PRELIMINARY DRAINAGE REPORT FOR URBAN LANDING PRELIMINARY PLAN

CCES Responses

Job No. 1308.01 PUDSP243
PCD File No.

DESIGNED BY	MAW	SCALE	DATE	3/21/24
DRAWN BY	MAW	(H) 1" = 100'	SHEET	1 OF 2
CHECKED BY		(V) 1" = N/A	JOB NO.	1308.01

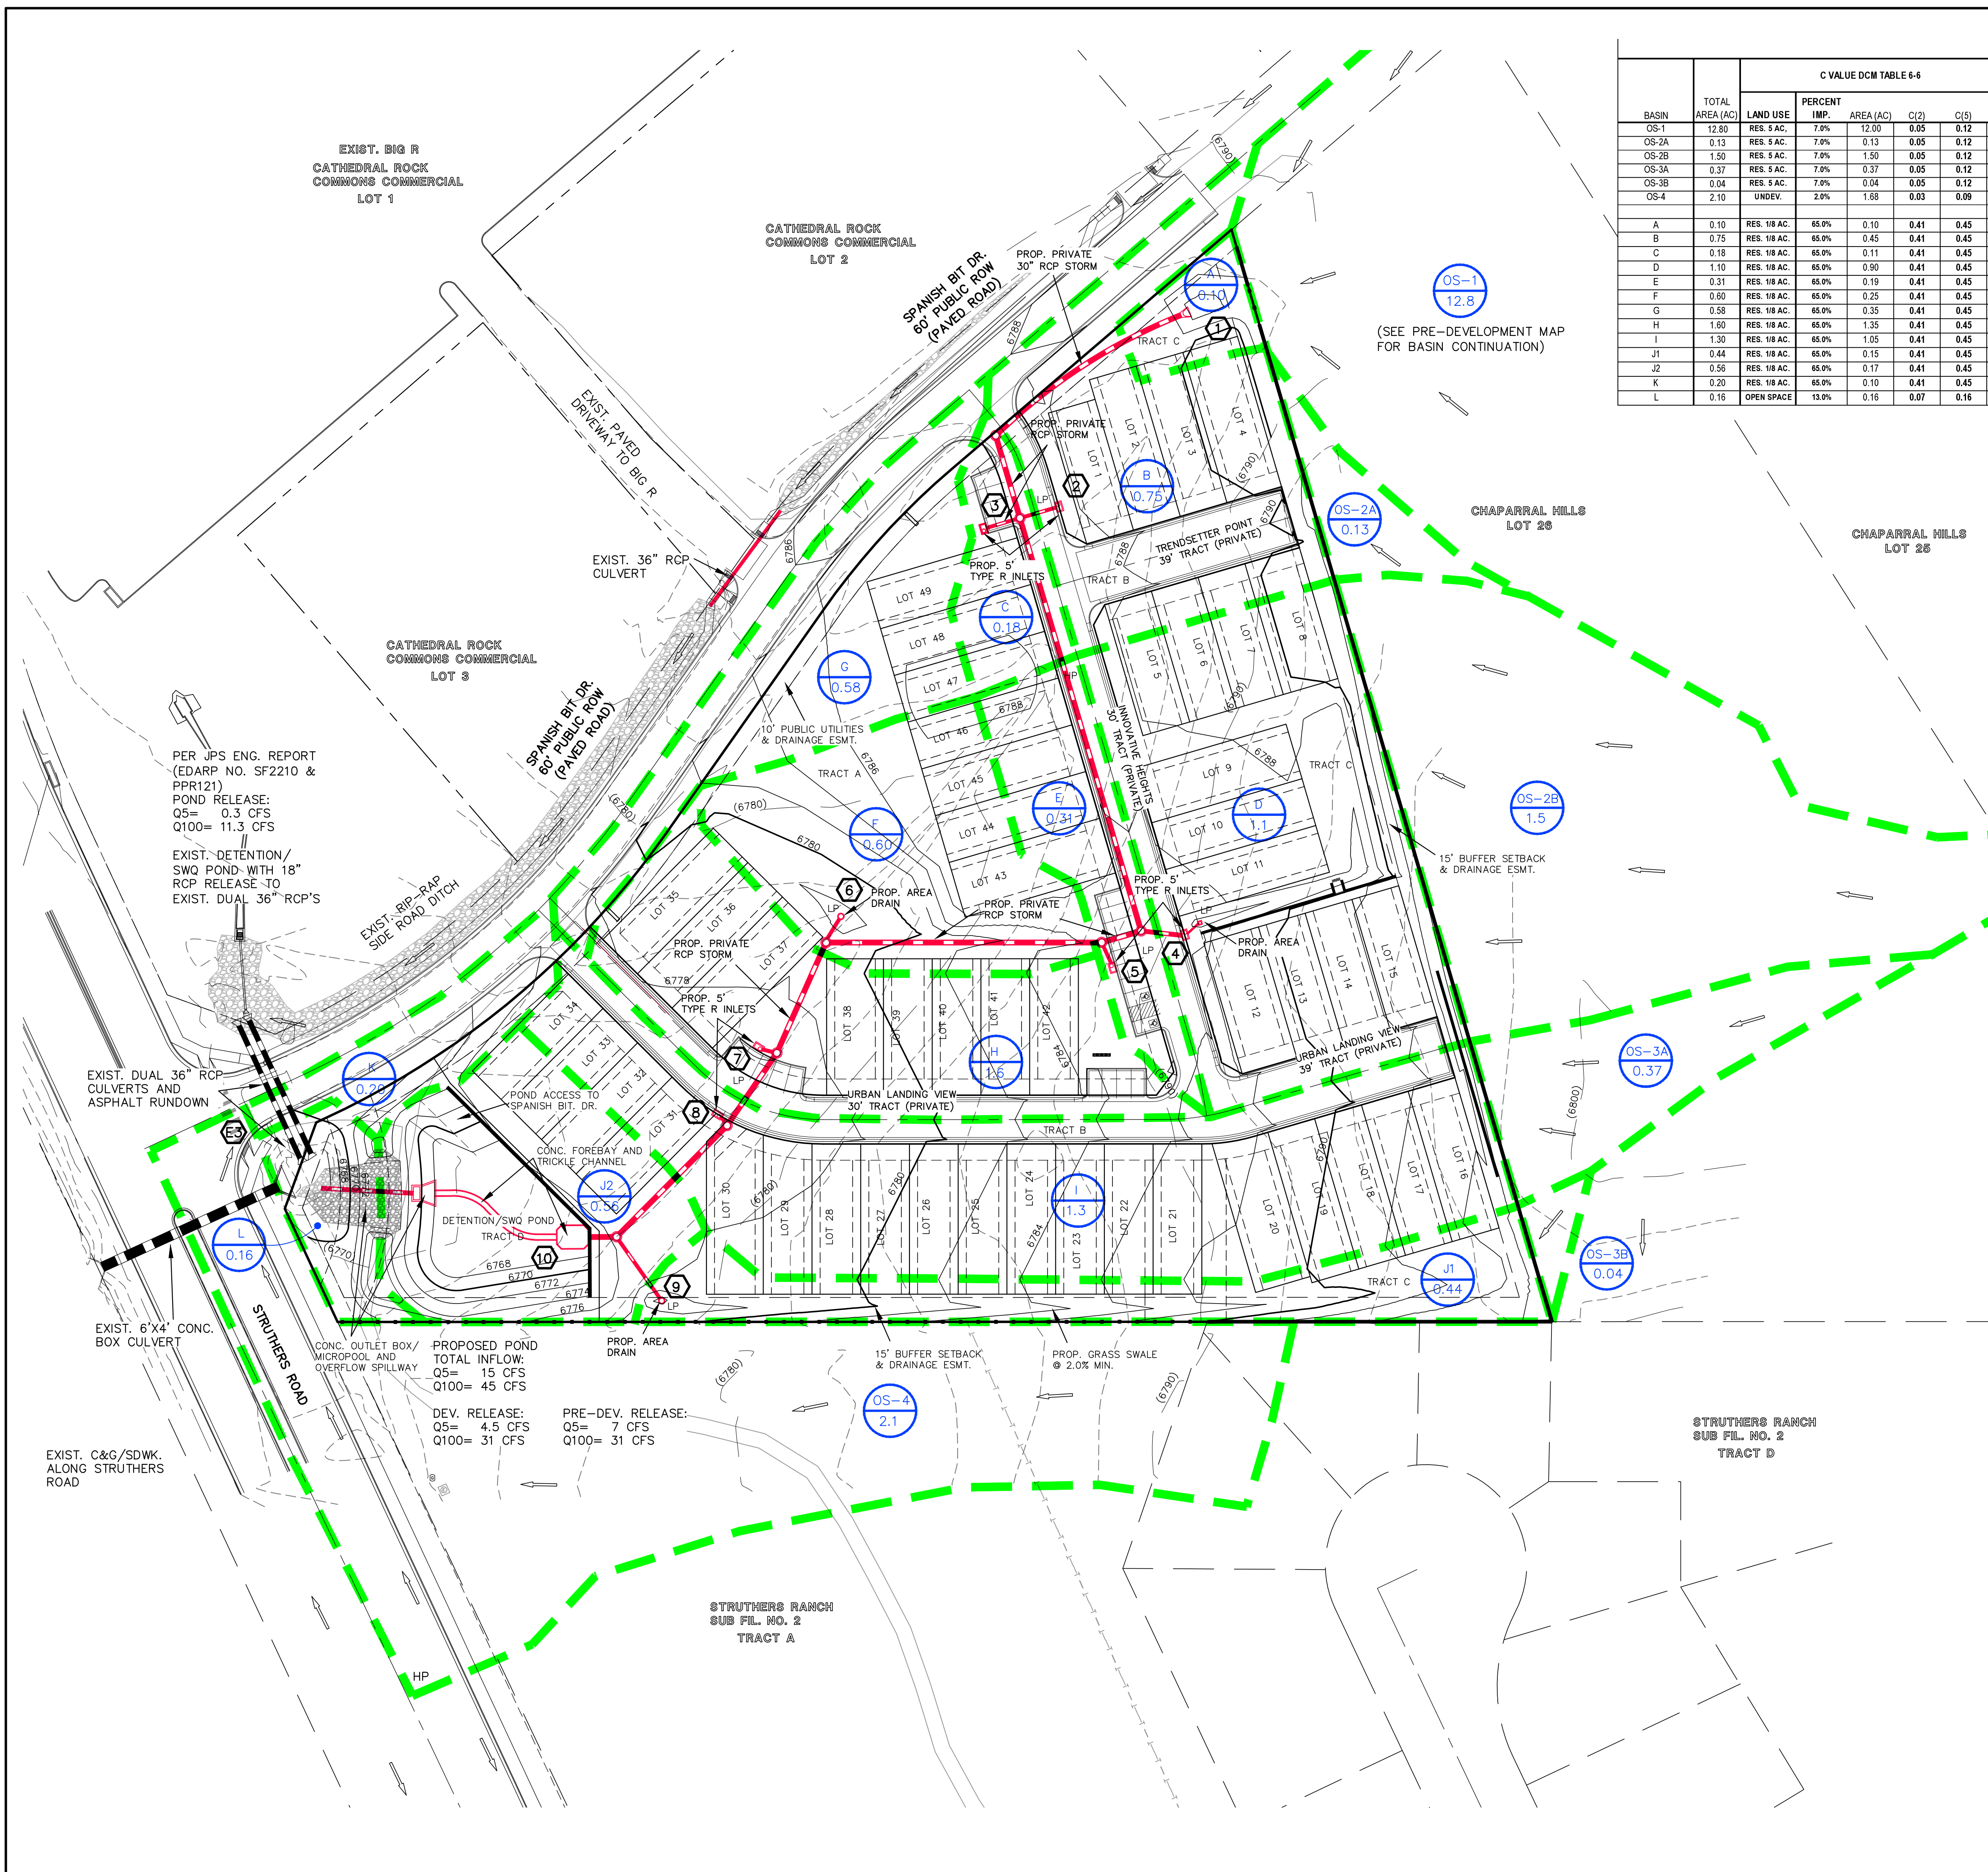
Concentrated flow from the proposed swale cannot be discharged directly into the proposed pond. Please provide a riprap rundown.

Basin OS-4 (2.1 ac.) ($Q_5 = 1.6$ cfs, $Q_{100} = 5.1$ cfs) consists of the off-site sheet flows from the undeveloped church property to the south. These existing sheet Rip-Rap Rundown now provided side of Struthers Road and then travel as curb and gutter flow in a nortnerly direction towards Spanish Bit Dr. Once at the intersection with Spanish Bit Dr., the flows travel around the corner, combine with the developed flows from Basin K and are then conveyed directly into the existing holding basin on the southeast corner via an existing paved rundown. These existing flows are then routed under Struthers Road via the existing 6'x4'CBC. Basin K (0.20 ac.) ($Q_5 = 0.6$ cfs, Q_{100} = 1.2 cfs) consists of the developed flows from a small portion of the development property and the south side of Spanish Bit Road. These develope Added additional gutter flows language. See revised towards the existing paved rundown. Basin L (0.16 ac s) consists of
